CITY OF ALBUQUERQUE

October 31, 2017

**Re: Broadstone Highlands
Erosion and Sediment Control Plan
Engineer's Stamp Date 10-26-17 (K15E034A)**

EROSION AND SEDIMENT CONTROL PLAN

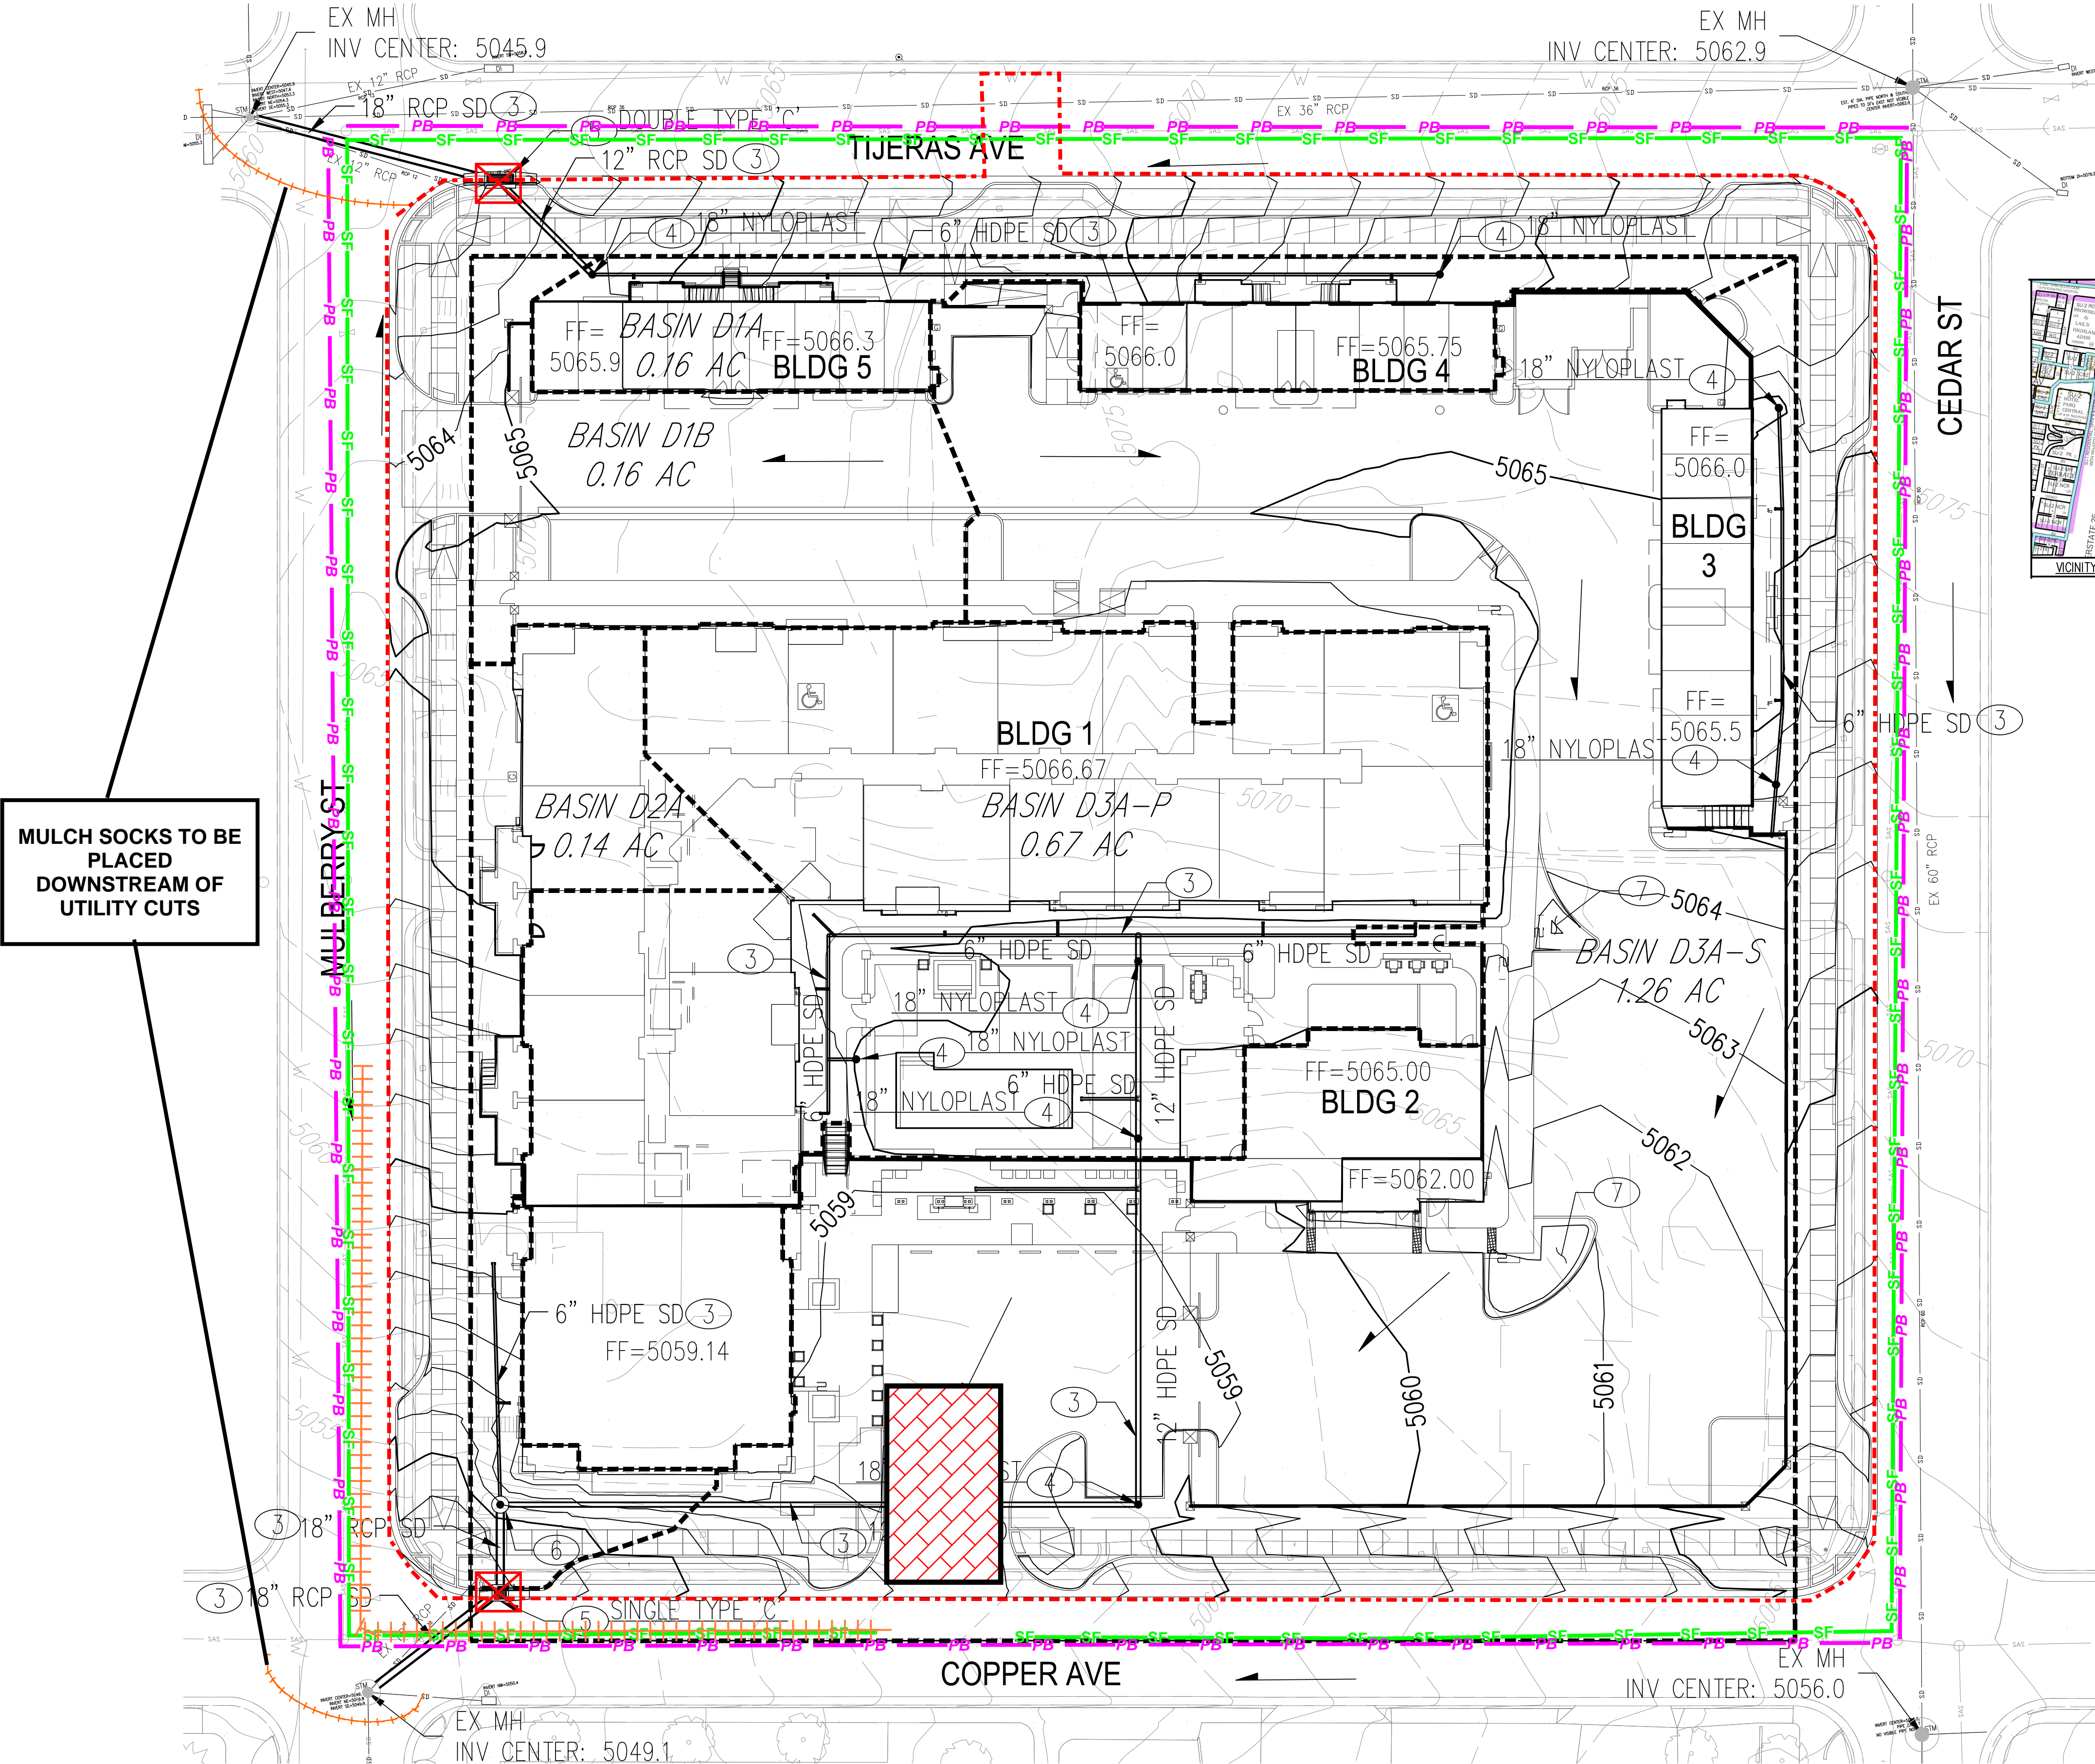
1. Since the streets are steep: for the street work, mulch socks or similar should be placed at the downhill end of each block.
2. On-site slopes are approximately 5%. If the silt fence is loading- up often or gets blown-out in the southeast corner, a pond will be required.
